# Cottam Solar Project

## Change Request Notification

PINS reference: EN010133  
Document reference: CR1/C9.1

Cottam Solar Project – Notification of intention to make a change request  
Application Ref: EN010133

**Site Access Arrangement And Visibility
Splay To The North**

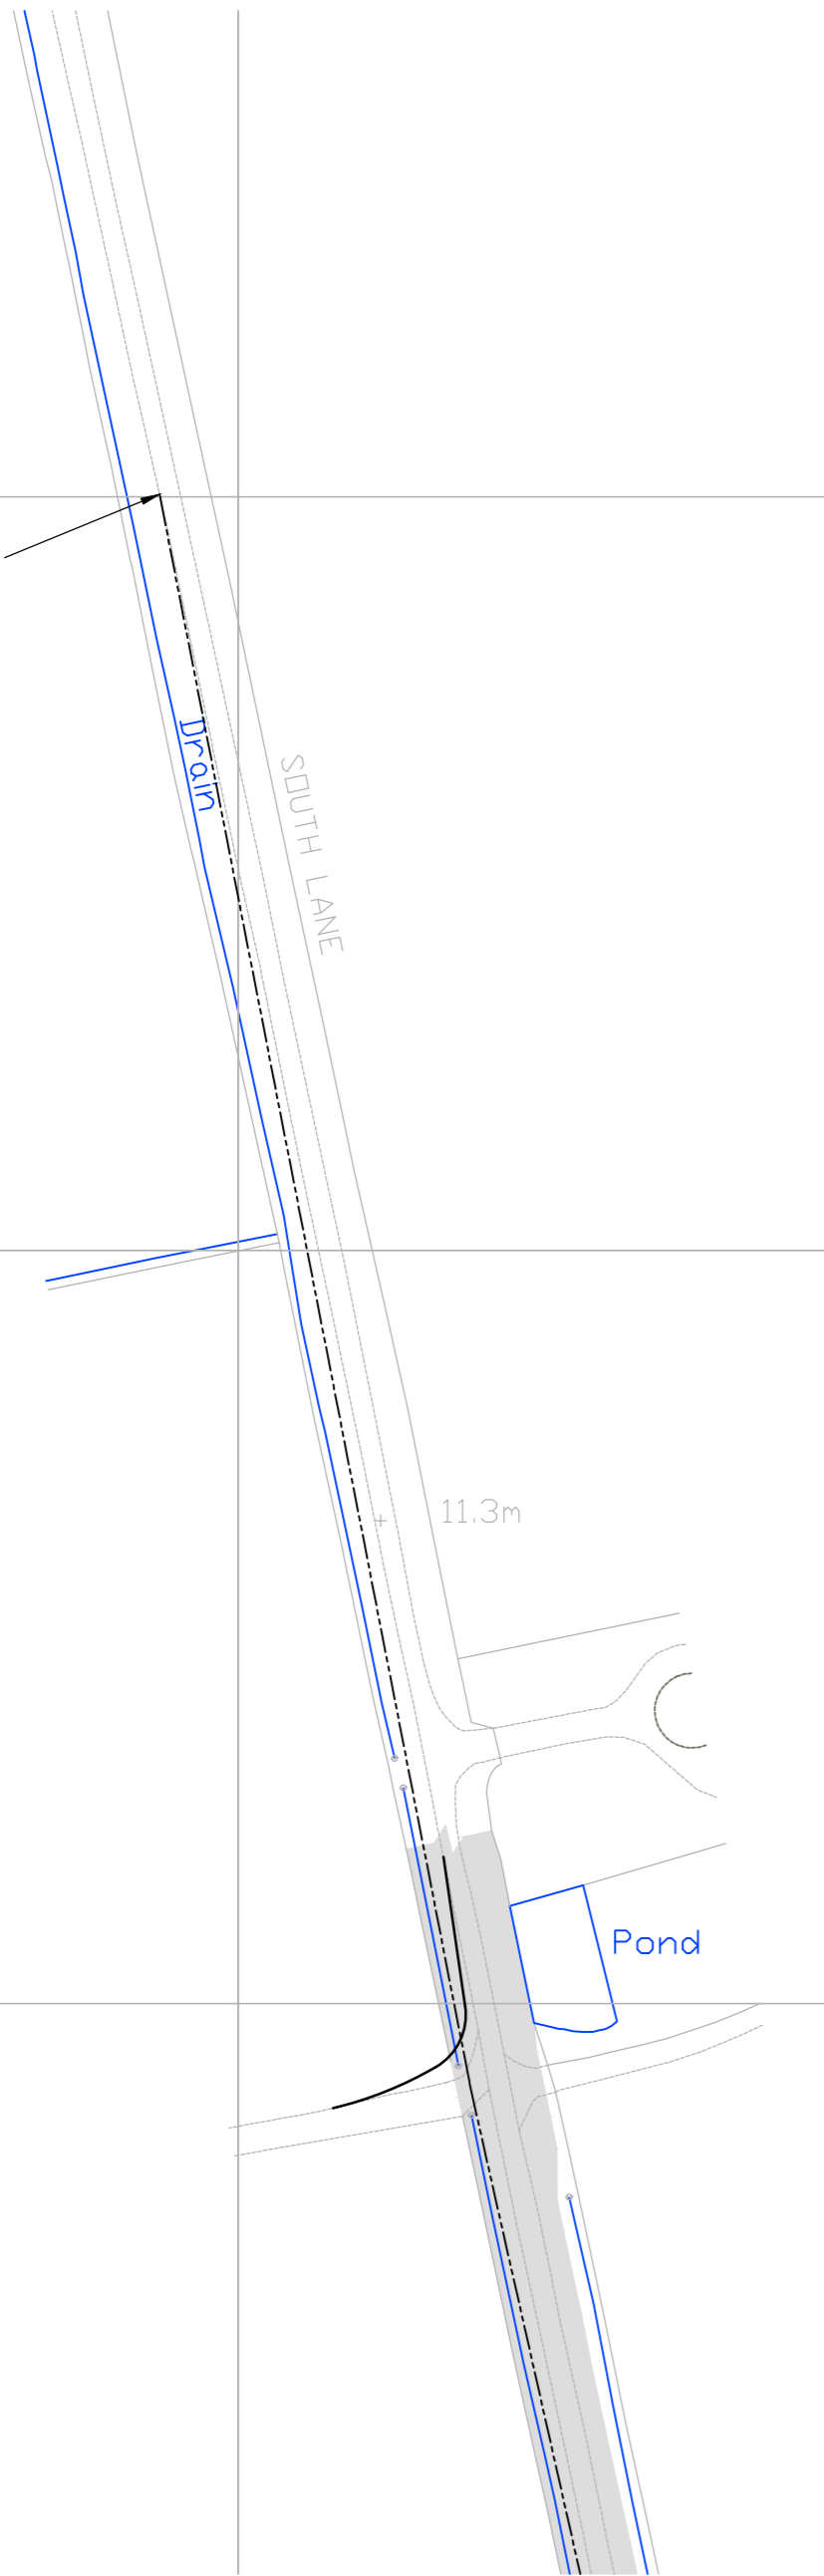
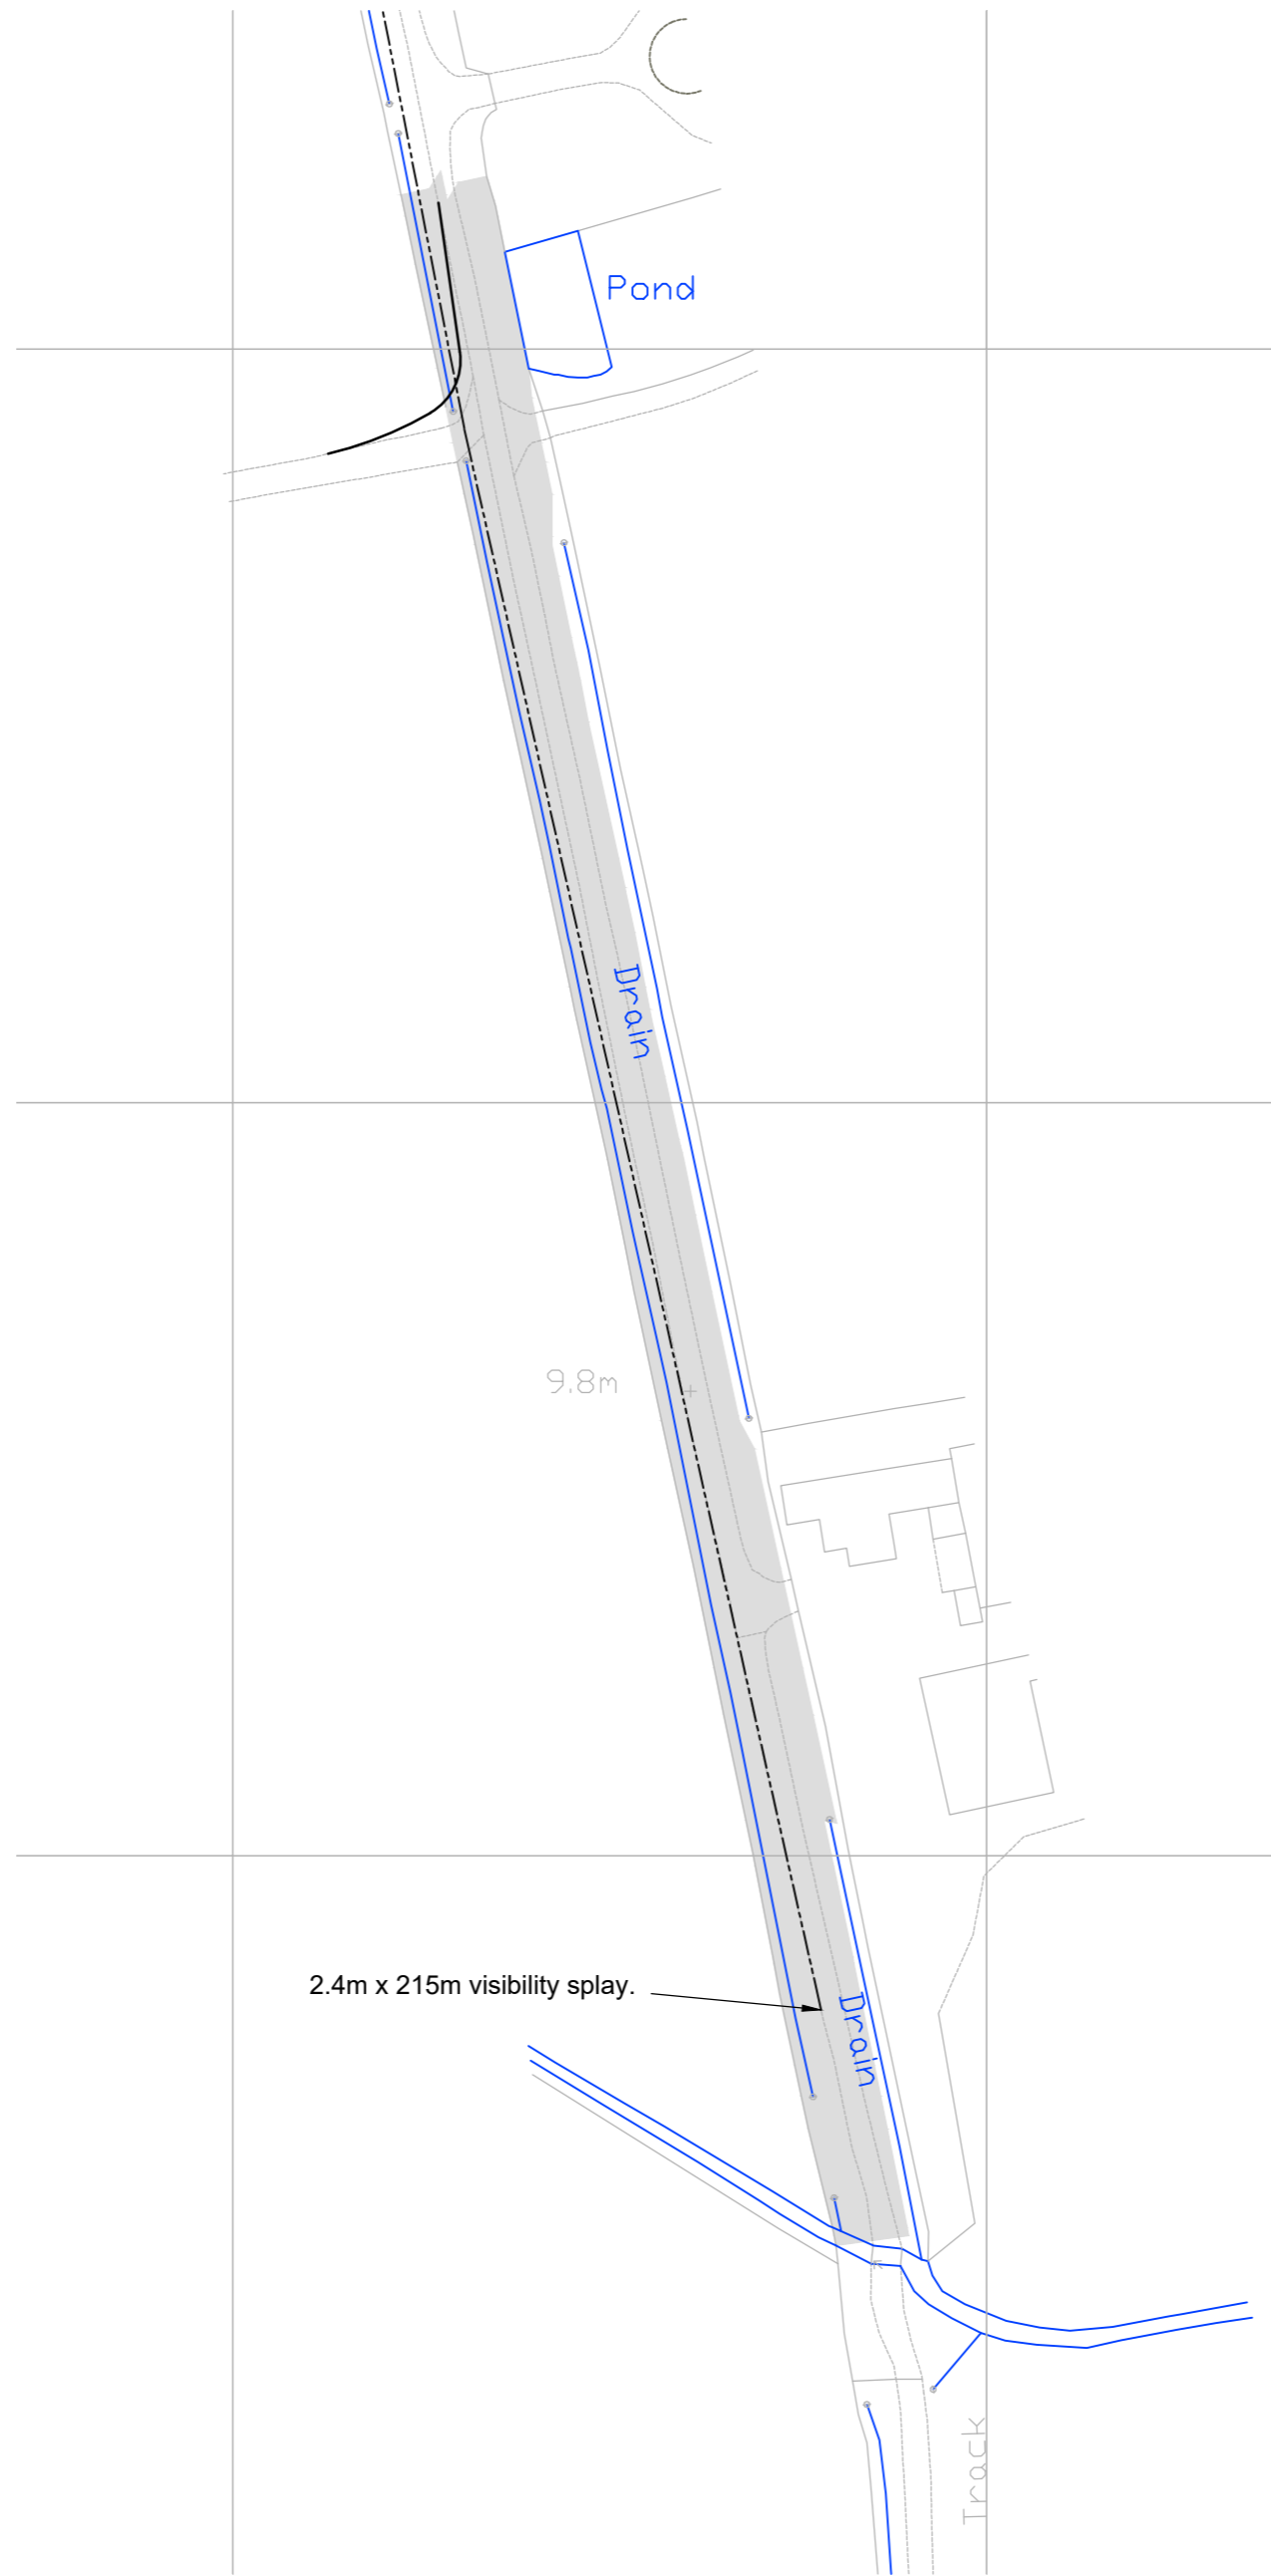
*Change 3: Visibility splay at Cottam Cable Route Corridor Access AC108*

Change 3 comprises a small extension to the Order Limits along A156 High Street, Marton in proximity to the Cable Route Corridor construction access point reference AC108.

A review of the construction access points to ensure coordination with the access points for the Gate Burton Energy Park has indicated that construction access AC108 requires a longer visibility splay to the north.

This extension would mean that the Order Limits for Cottam Solar Project would match those of Gate Burton Energy Park in this location.
